From: Amanda Scholes on behalf of Planning.Responses
Sent: 26 April 2018 09:03
To: Planning Scanning
Subject: FW: BE/37/18/CLP - materials 24 Winston Close North Bersted Bognor Regis

BE/37/18/CLP – materials

Title
Elevations as Proposed

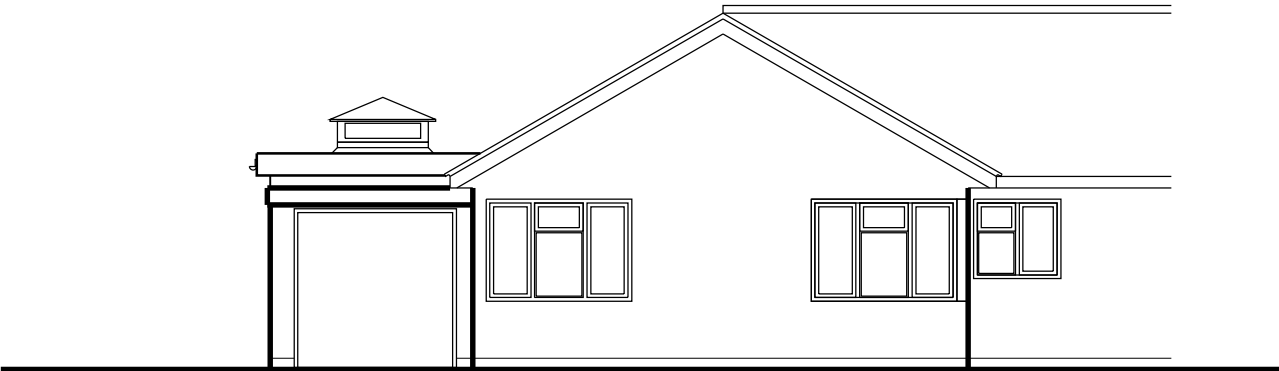
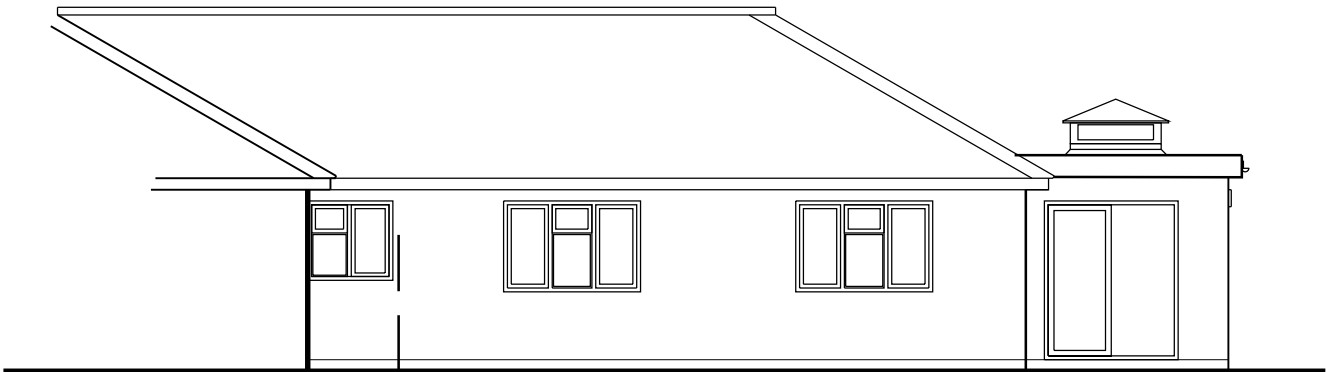
Can you please confirm that the facing brick, window frames, fascia boards and soffits will match the materials of the existing dwellinghouse.

We can confirm all materials will match existing of the existing dwelling
